Harnett County Government Complex  
307 Cornelius Harnett Boulevard  
Lillington, NC 27546

**Persimmon Hills**

**Re: Status of Improvement Permit Application #06-5-16337 – Lt 47  
#06-5-16339 - Lt 53**

JASON PRICE CONST. INC.
THE CUMBERLAND
LOT #53 PERSIMMONS HILL
SCALE: 1"=40'

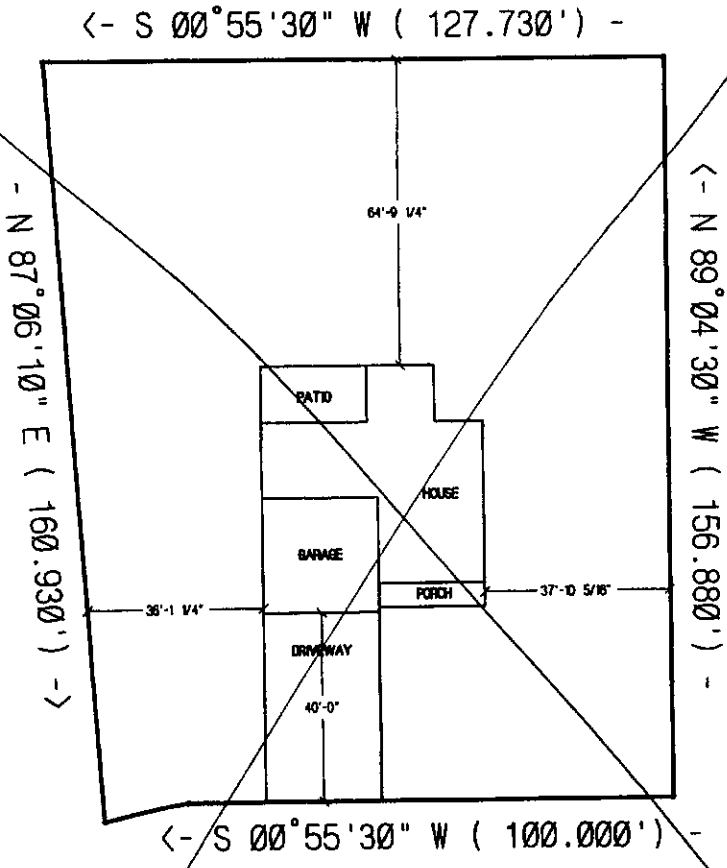
- \_\_\_\_\_ 1. Property lines/corners not marked or labeled
- \_\_\_\_\_ 2. House corners not marked or labeled
- \_\_\_\_\_ 3. Directions not clear to property
- \_\_\_\_\_ 4. Property needs brush or vegetation removed
- \_\_\_\_\_ 5. Backhoe pits required
- X   6. Other – **Move homes as shown on attached sheets. Submit your revisions to Central Permitting.**
